03 December 2021

Re: SSD-17424905 – 20 Avon Road, Pymble

We write to formally submit an objection to the proposed development on the following grounds:

Figure 6 Proposed Outdoor Play Aras

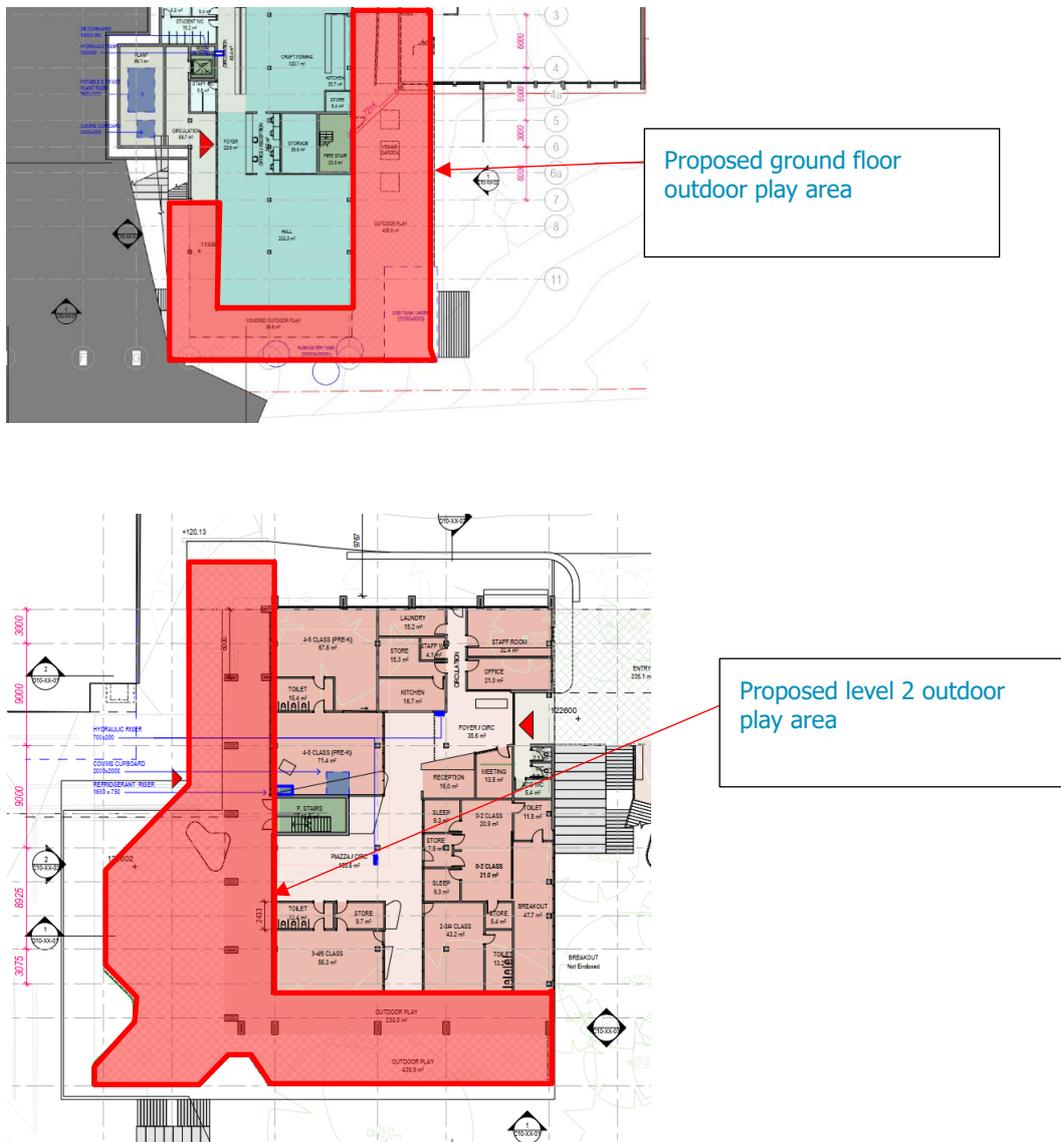
The NIA recommends a solid barrier to the perimeter of the level 2 external play area of the ELC, such as glass or the like with a height of no less than 1.5m above the floor of level 2. However, the architectural plans indicate a metal palisade fence to the perimeter of the level 2 outdoor play area. Further, the wind study recommends a 1.5-1.8m high impermeable or 30% porous screen along the north-eastern and south-eastern boundaries of the level 2 outdoor play area – see extract from NIA below:

SHADOW DIAGRAMS -
SHEET 3

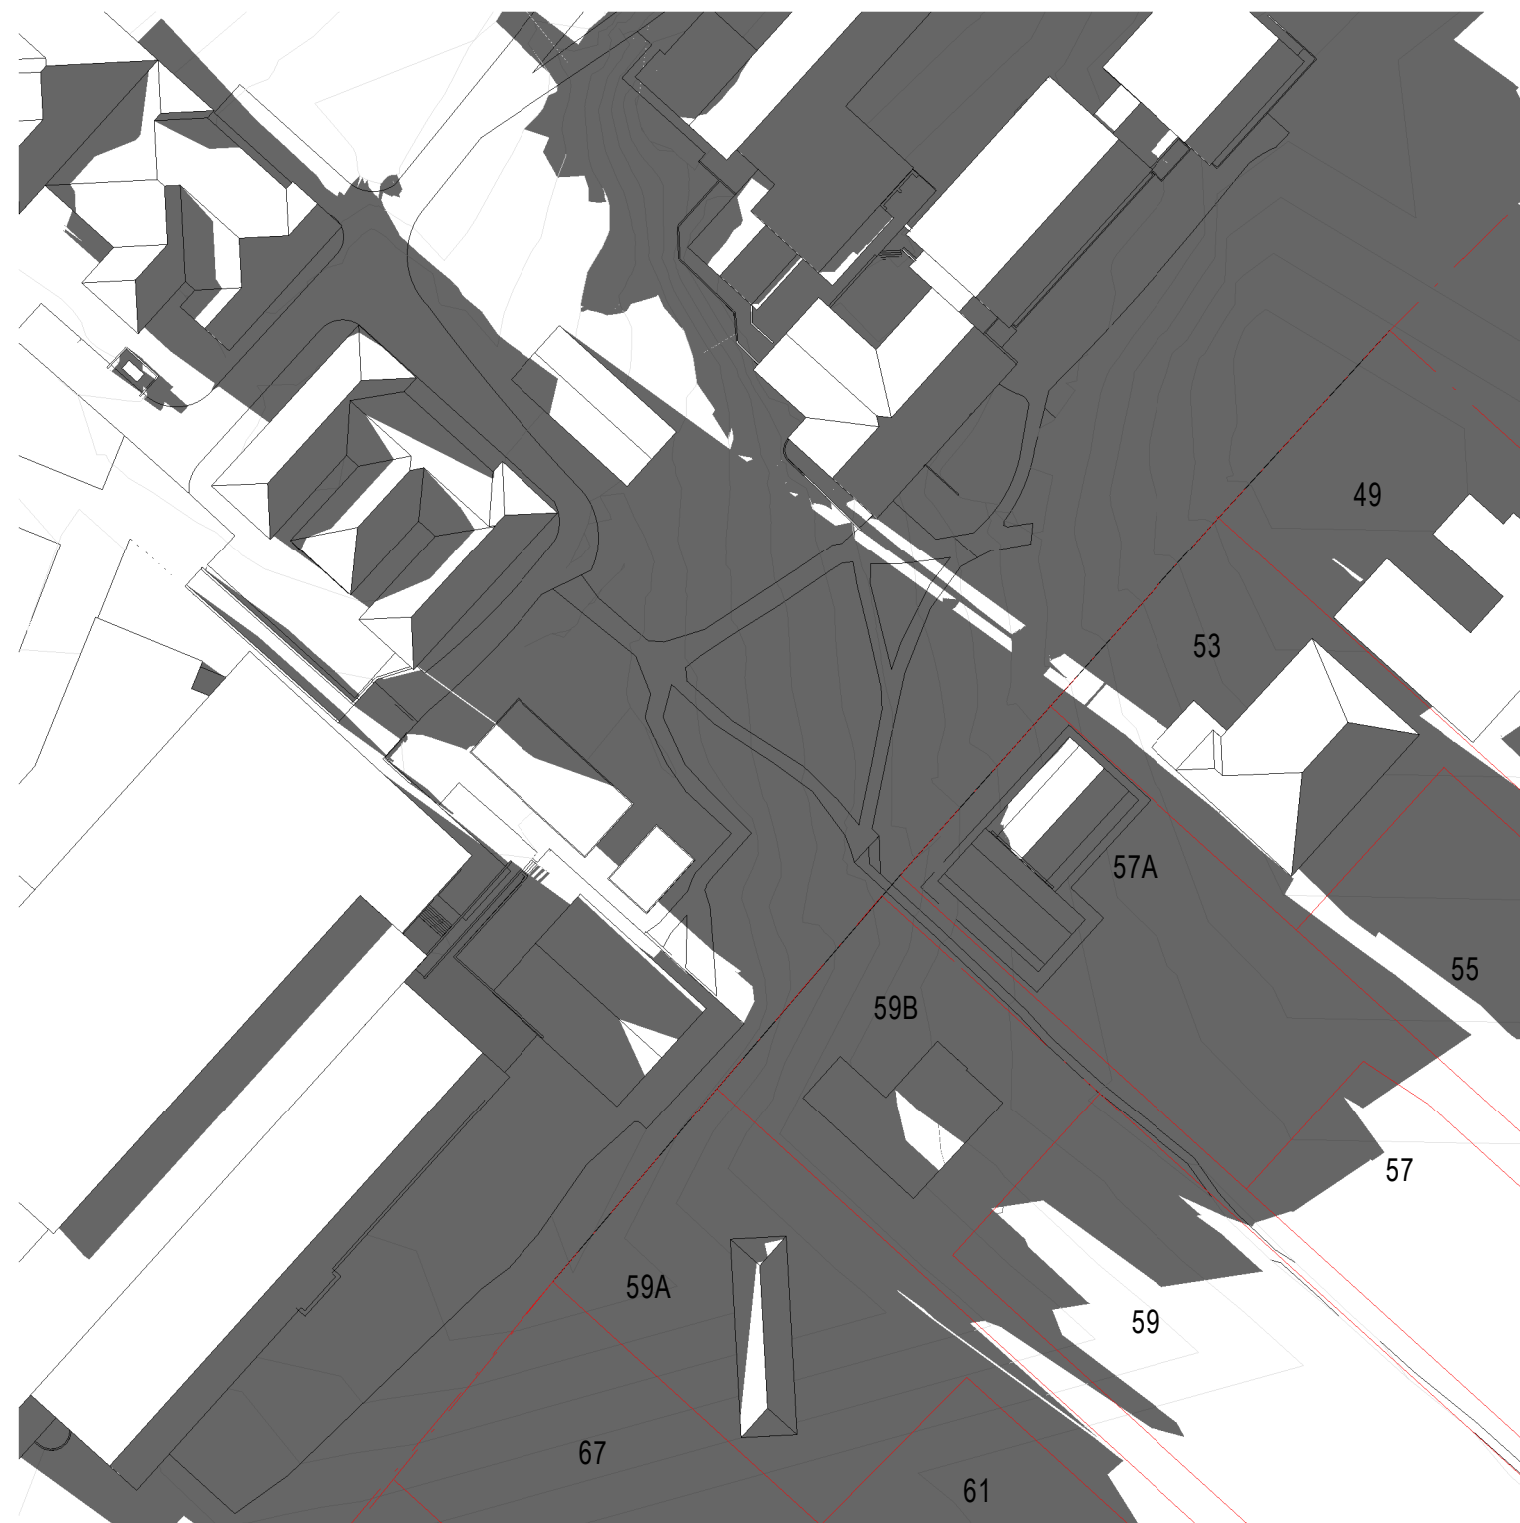
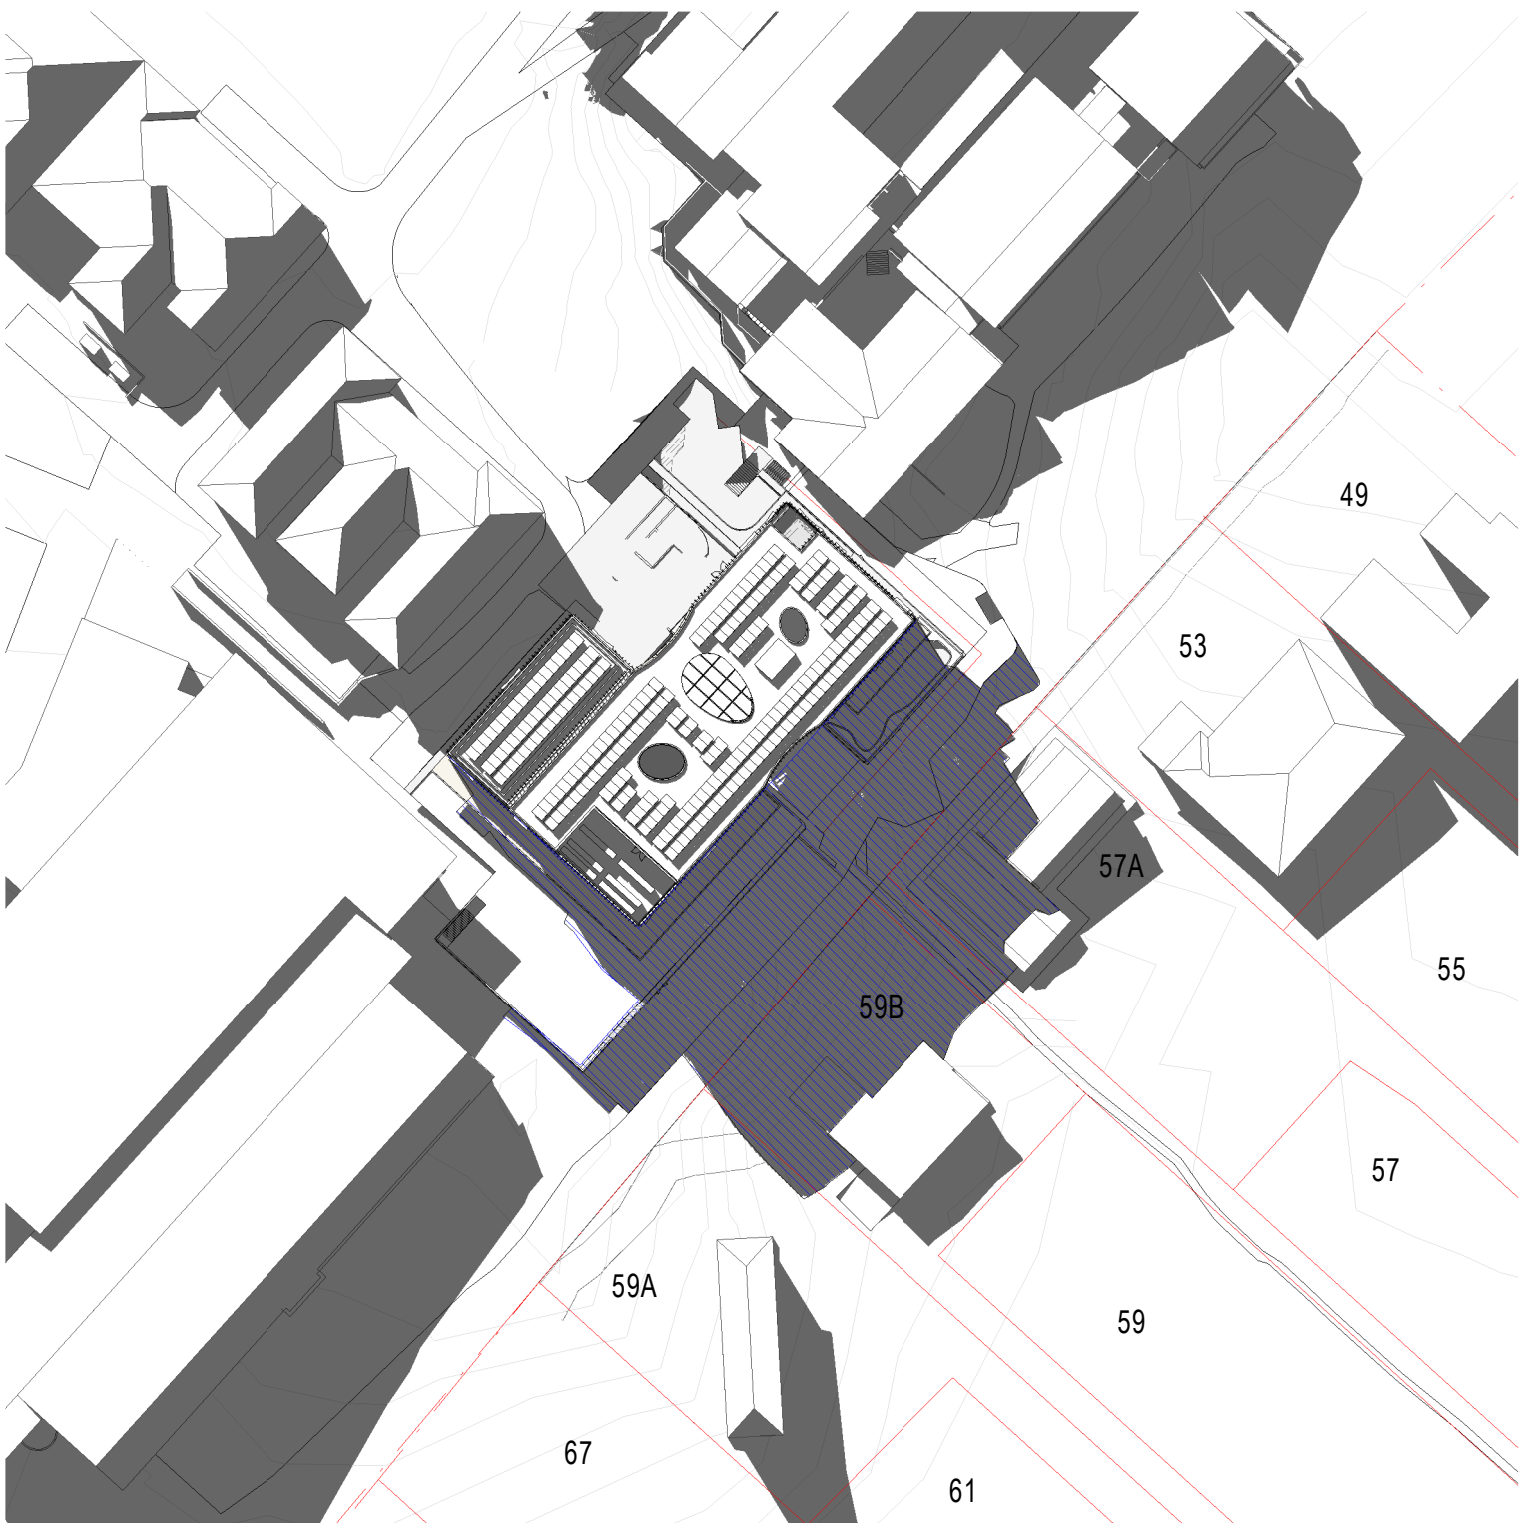
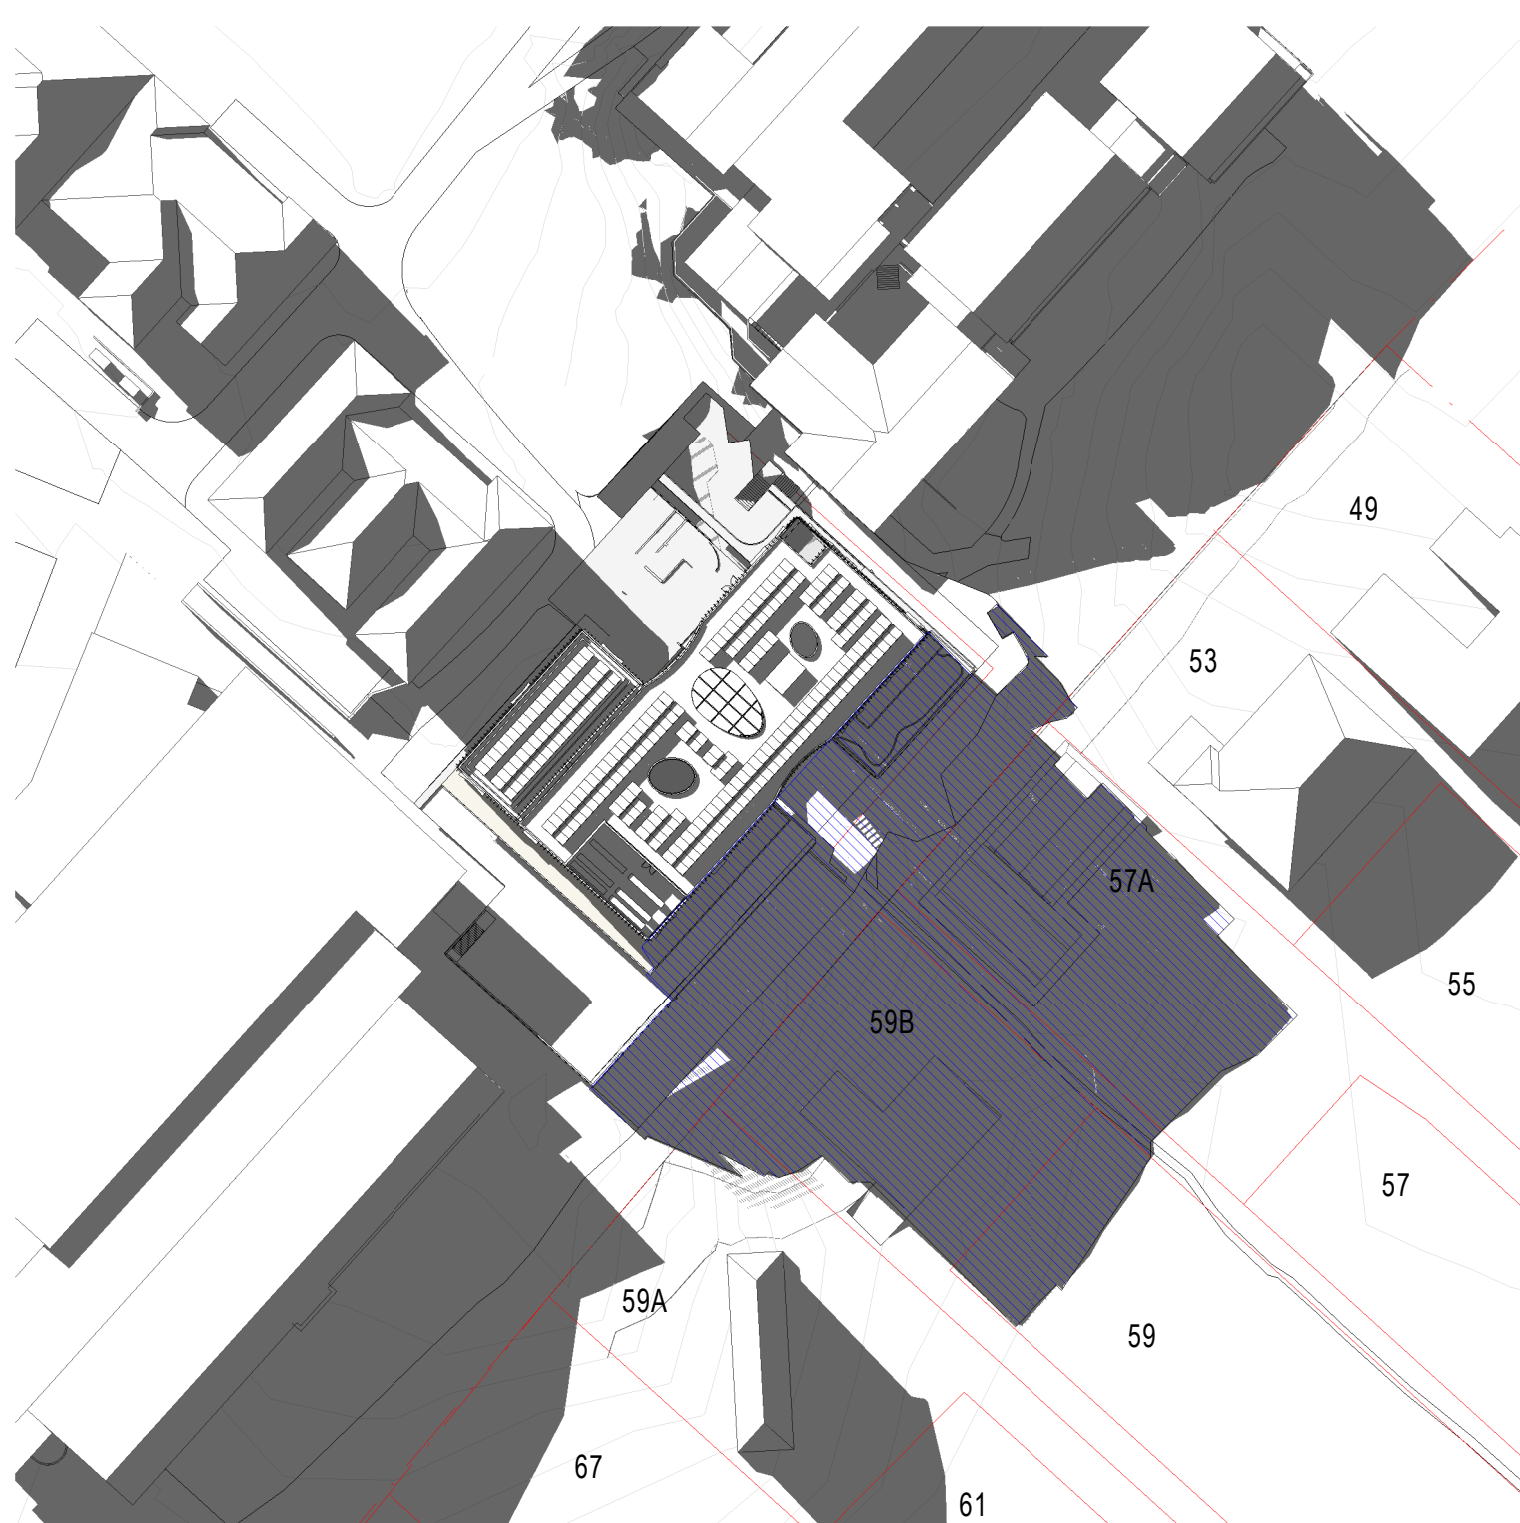
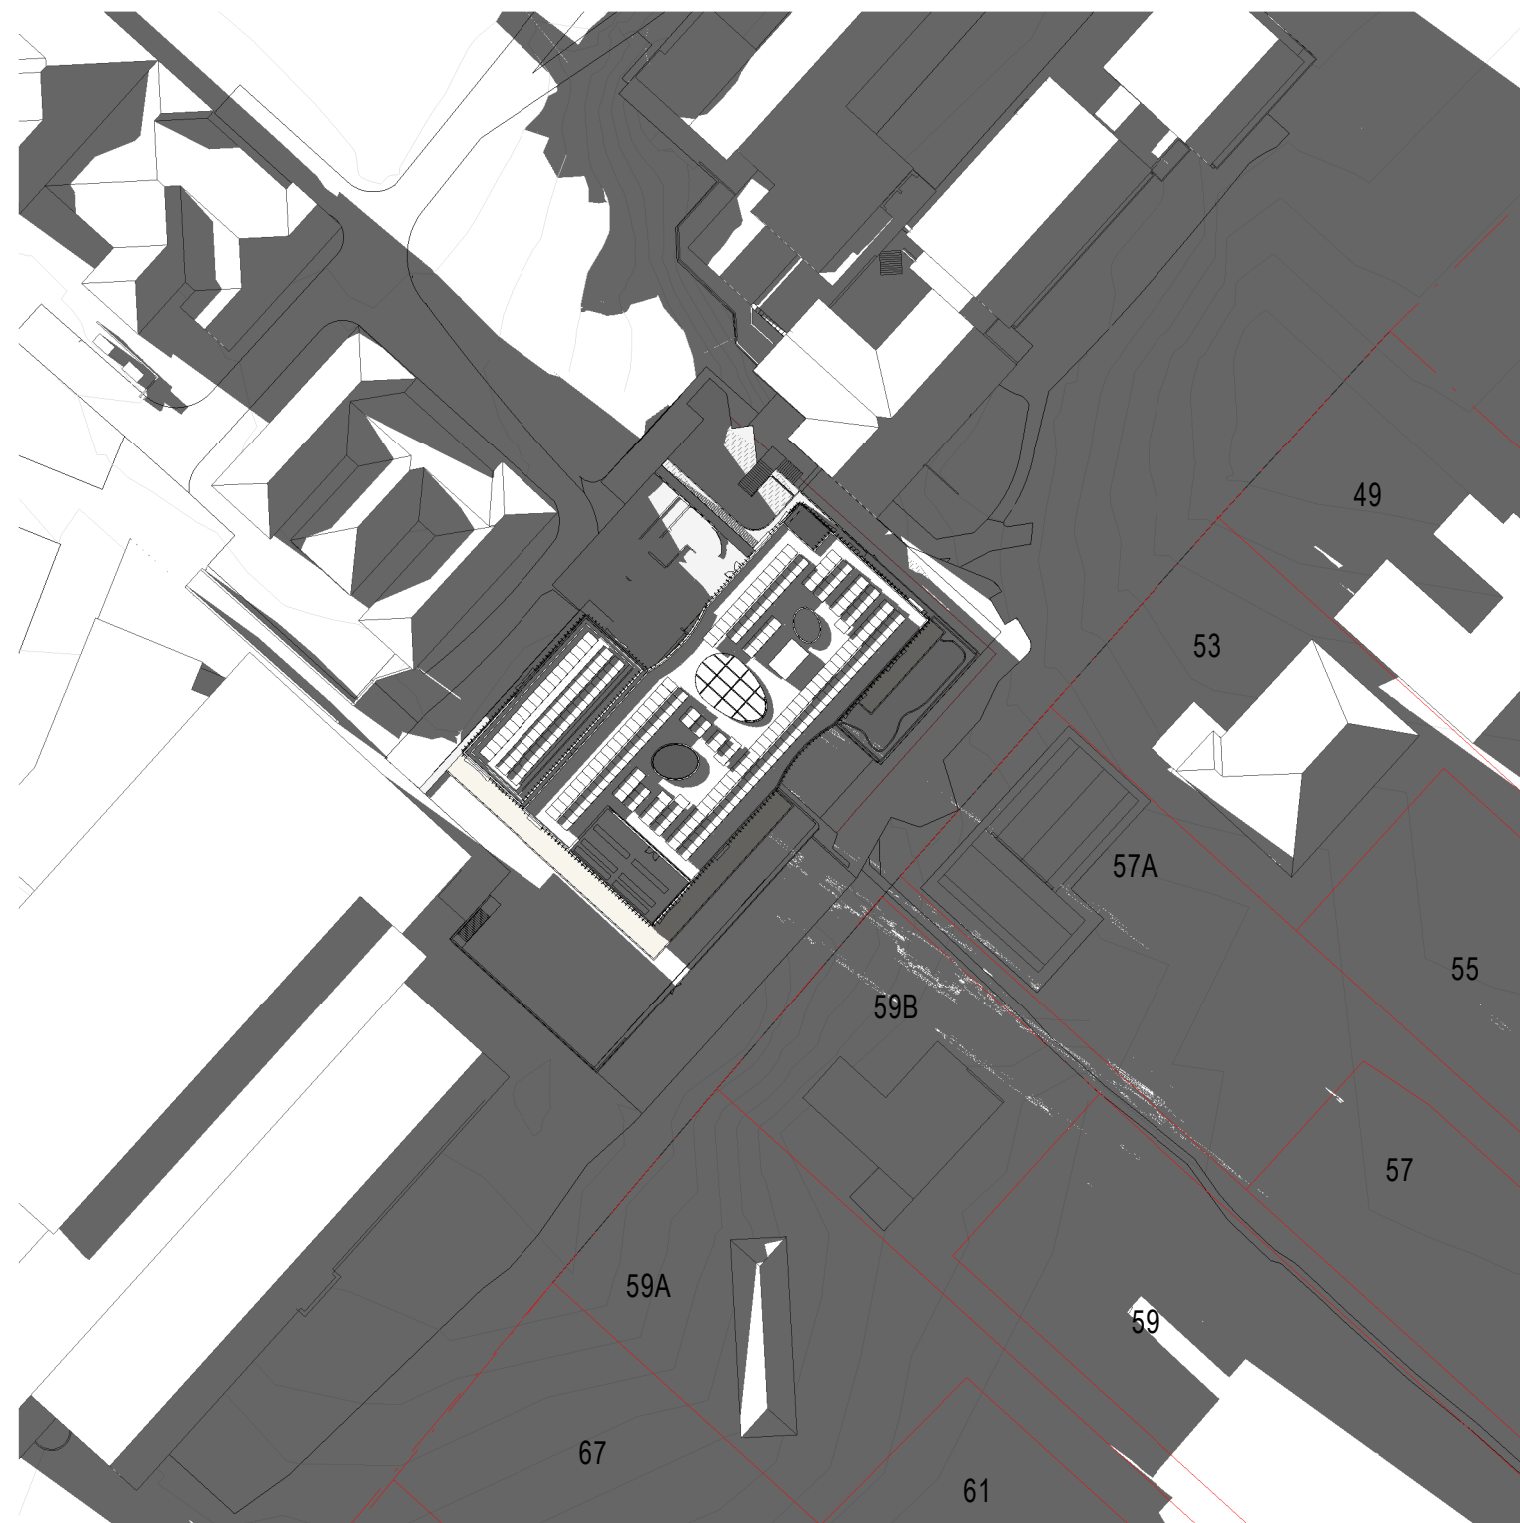
The proposal will result in the loss of afternoon sun from 12:30pm onwards, completely overshadowing the swimming pool and outdoor private open space from 1:30pm onwards.
